Consultation Response from KC, Policy		
2021/90357 East Bierley Playing Fields, Hunsworth Lane, East Bierley, BD4 6PU		
Works to existing sports facilities including erection of a clubhouse, additional changing facilities building, boundary treatments, storage facilities and floodlighting, works to existing pitches, and creation of new hybrid and five-a-side pitches and car park		
Date Responded:21/07/2021	Responding Officer: Amanda Potter & Andrea Lane	Responding Ref:

Proposal:

Proposed New Land
Allocation Plan

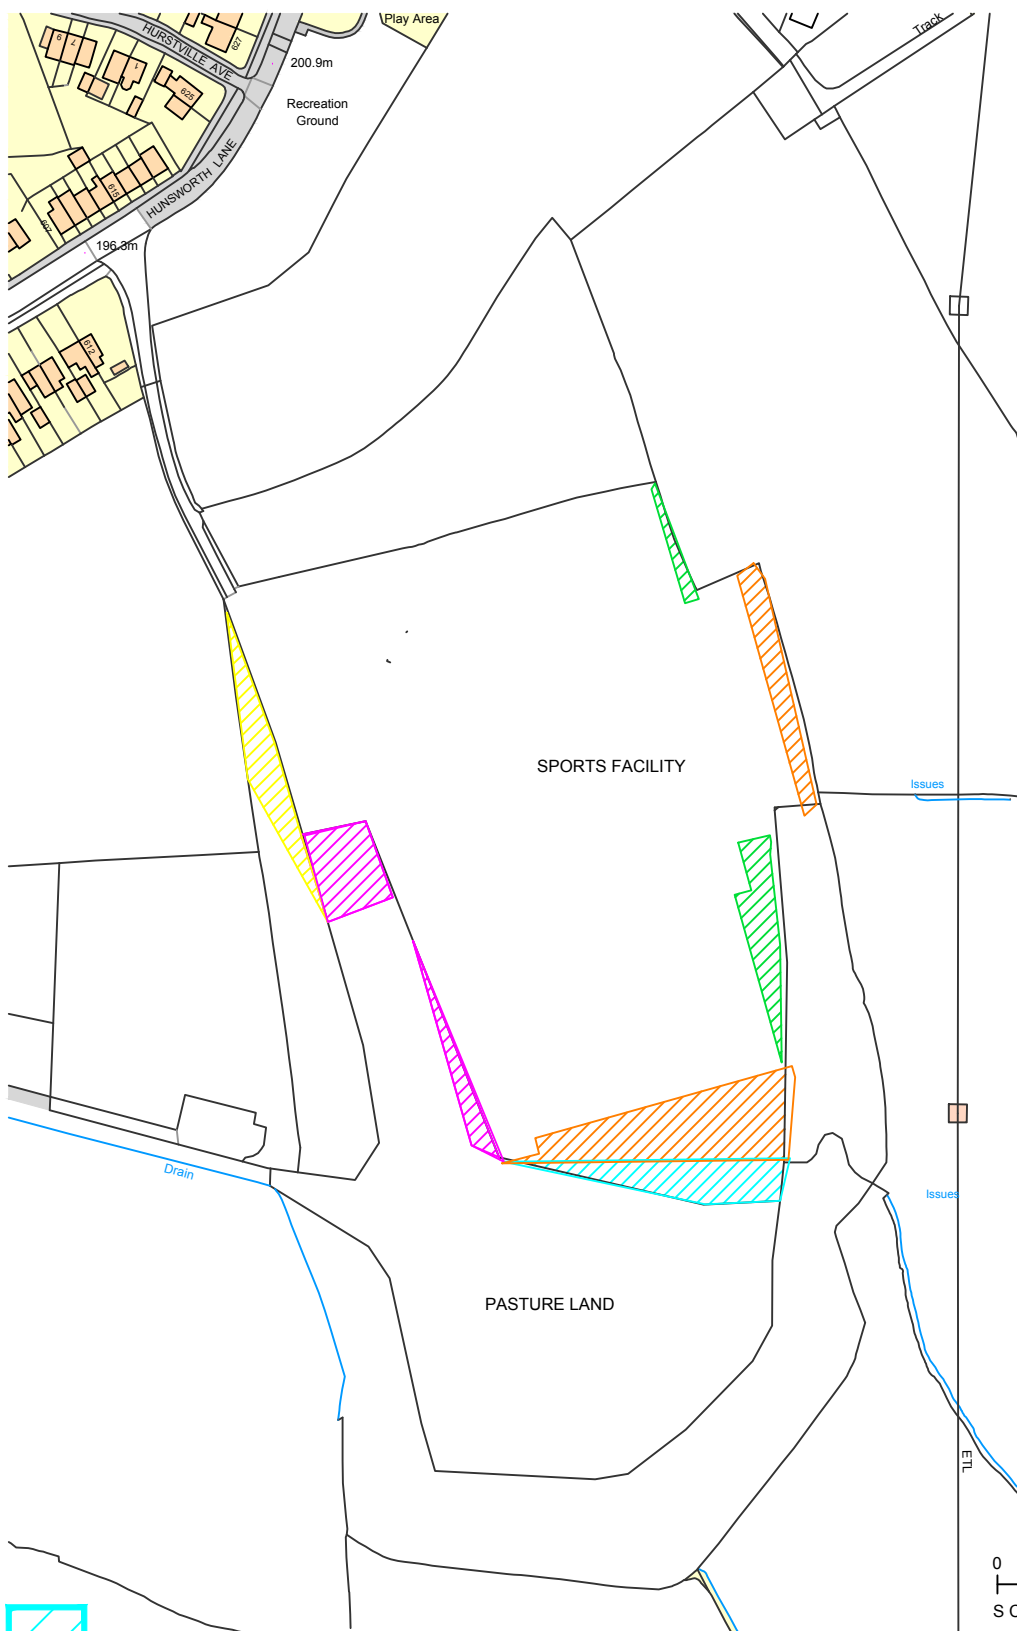
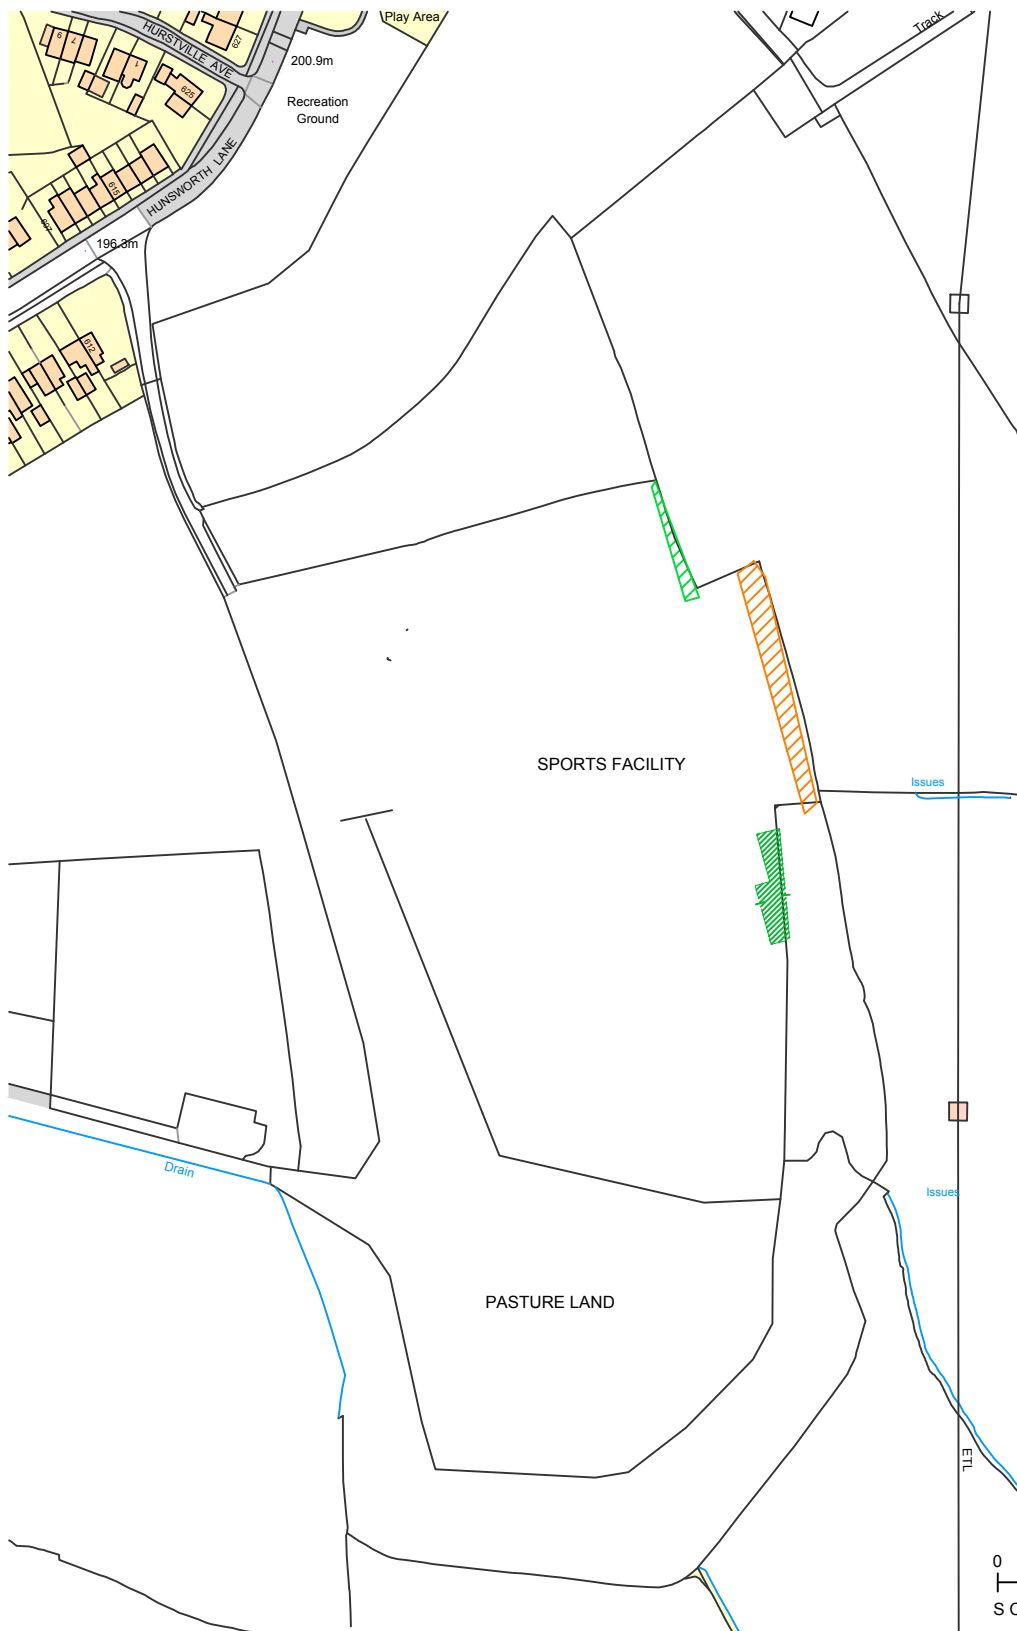
The application also proposes the change of use of an area of pasture at the rear of the existing changing rooms to accommodate a new changing room building, additional to the existing changing rooms building which is proposed to be retained. Some additional car parking is also proposed in this area. This new building should be considered against paragraph 149 criterion b) as an appropriate facility for outdoor sport as changing rooms would reasonably be required on such a site. However, there is no information as to why it is necessary to have 2 changing room buildings on site. A new building where no building currently exists would not preserve the openness of the green belt and the expansion of the site beyond its current limits would lead to encroachment into the countryside contrary to the purposes of including land within it. To compensate for the loss of the area of pasture the plans show a new area of pasture to the south of the site. However, the compensatory area of pasture would be created where land is already free from development while the pasture to be lost would be to accommodate a building and car parking. The one does not therefore compensate for the other.

| East Bierley Community Sports Association | Proposed Fencing Design |          |       |         |

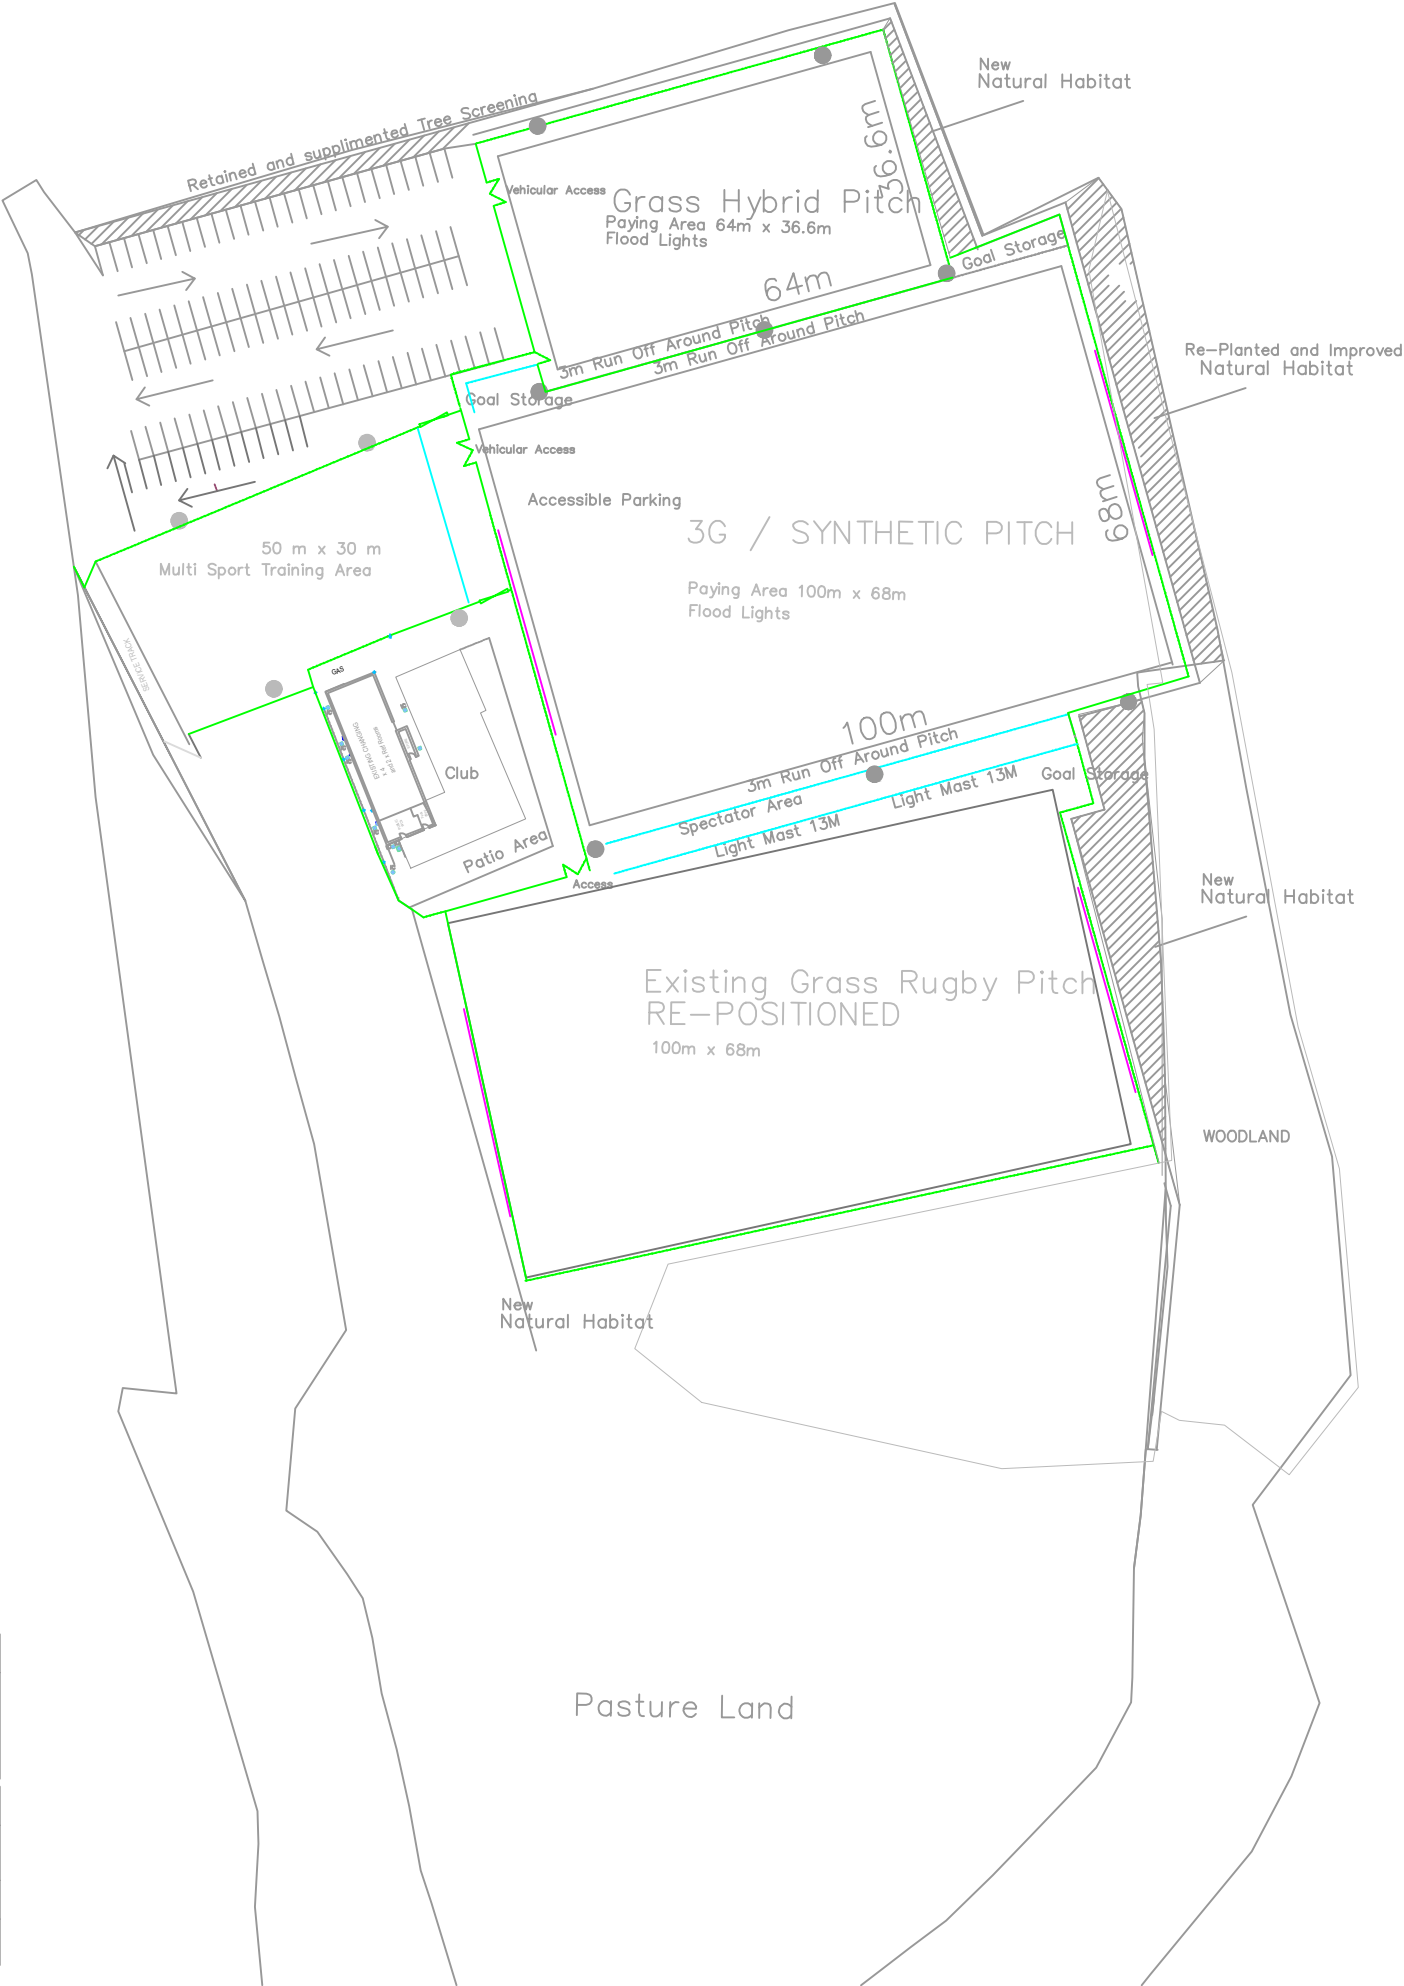
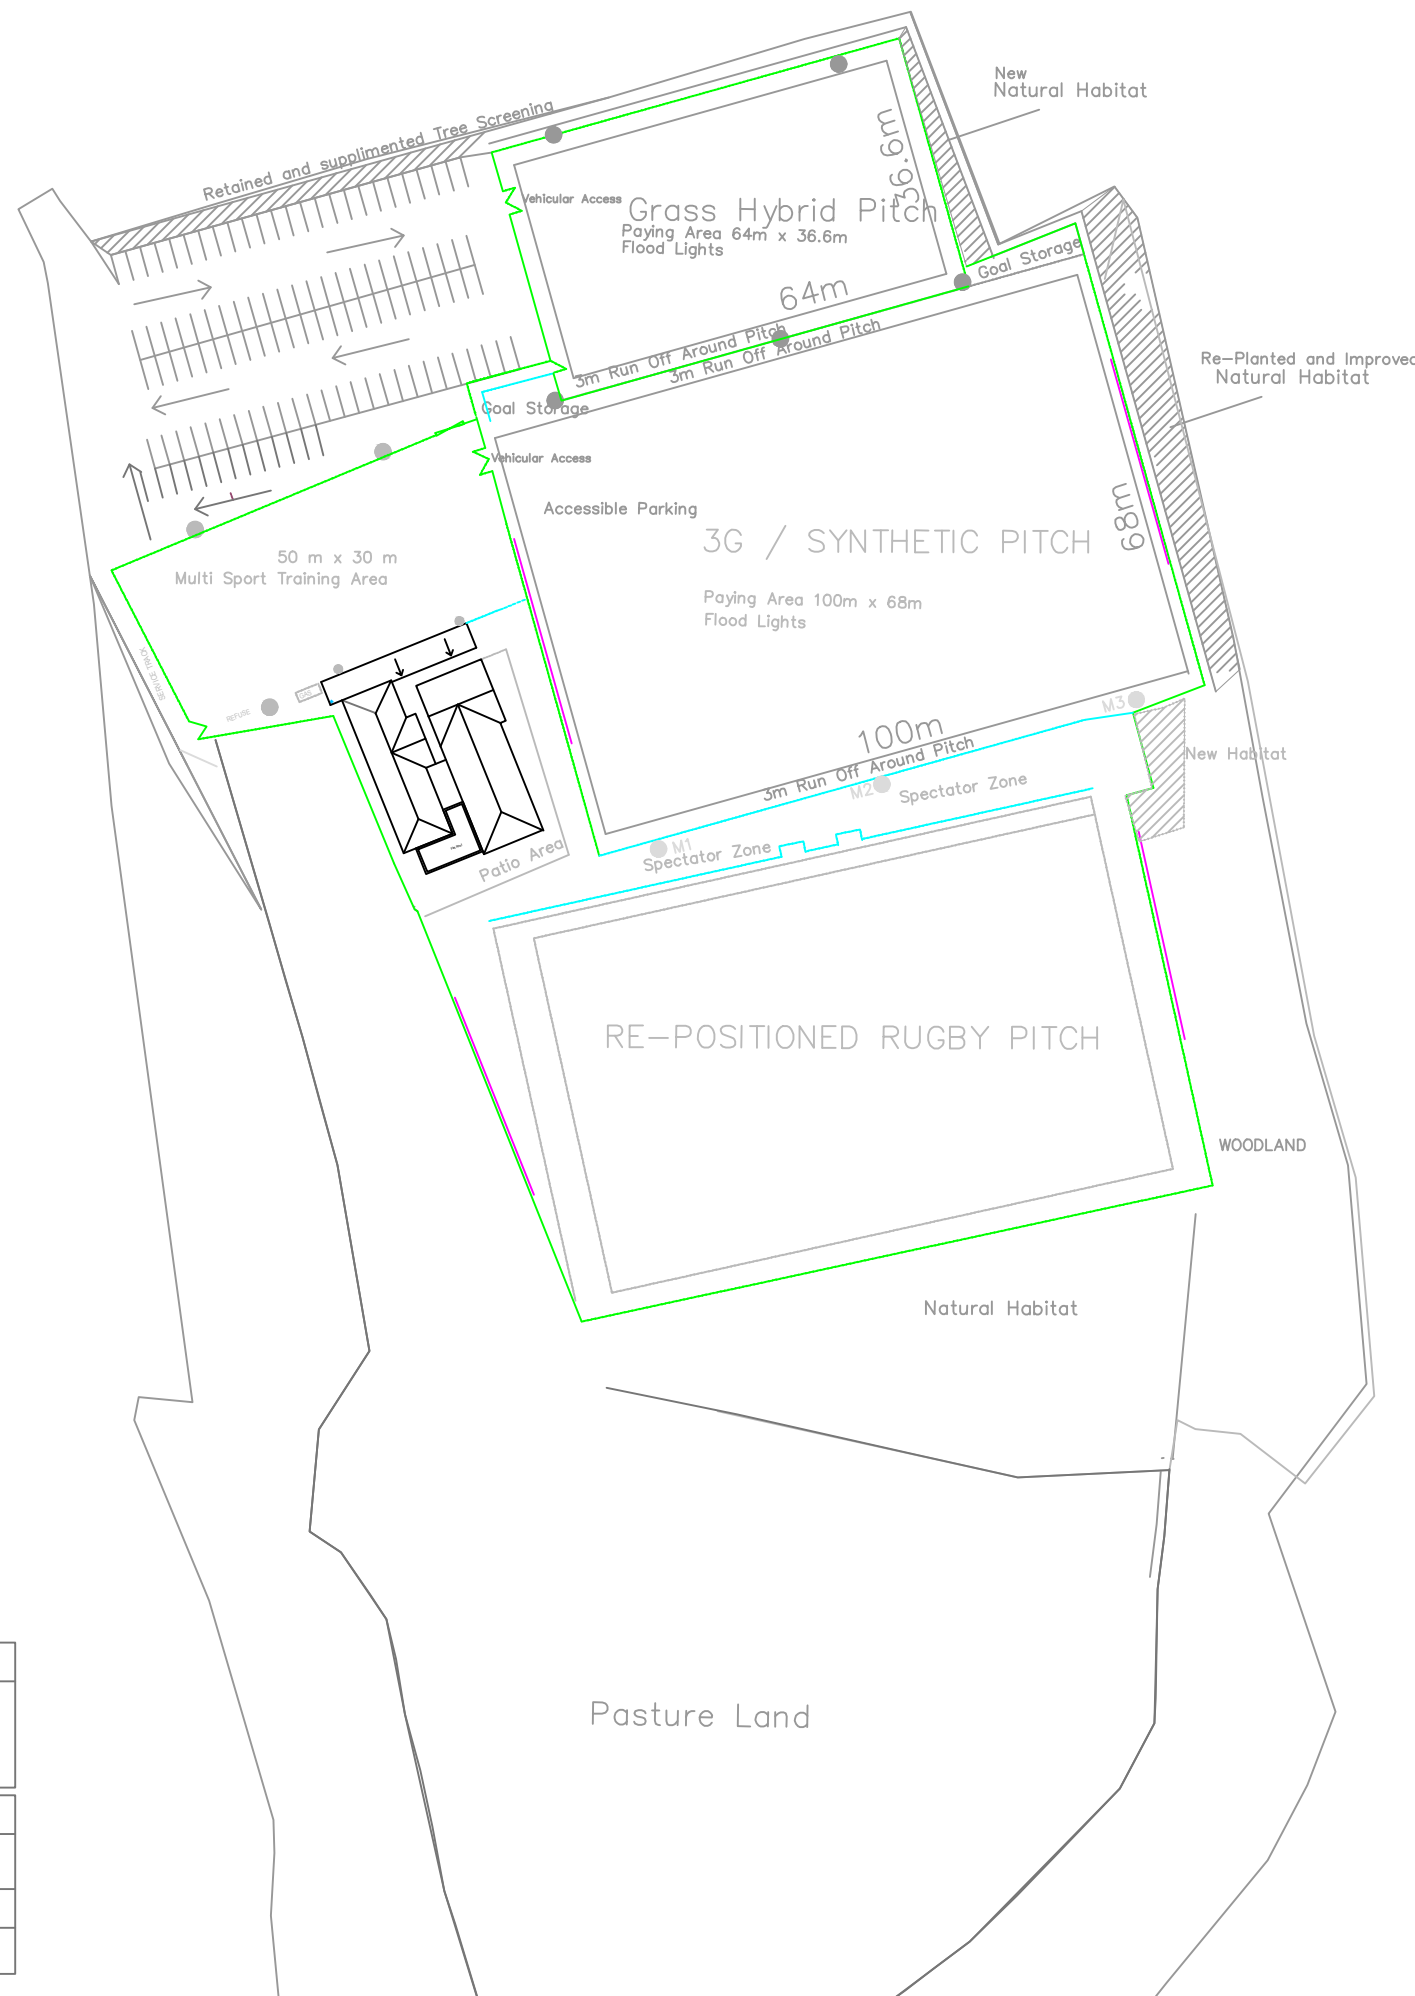
are limited, but the lighting will still be highly visible and a significant intrusion into the countryside that surrounds the site. The enclosures and the floodlighting as well as noise resulting from the increased level of use of the site both during the day and into the evening would impact on openness as well as introducing urbanising features into a green belt setting.
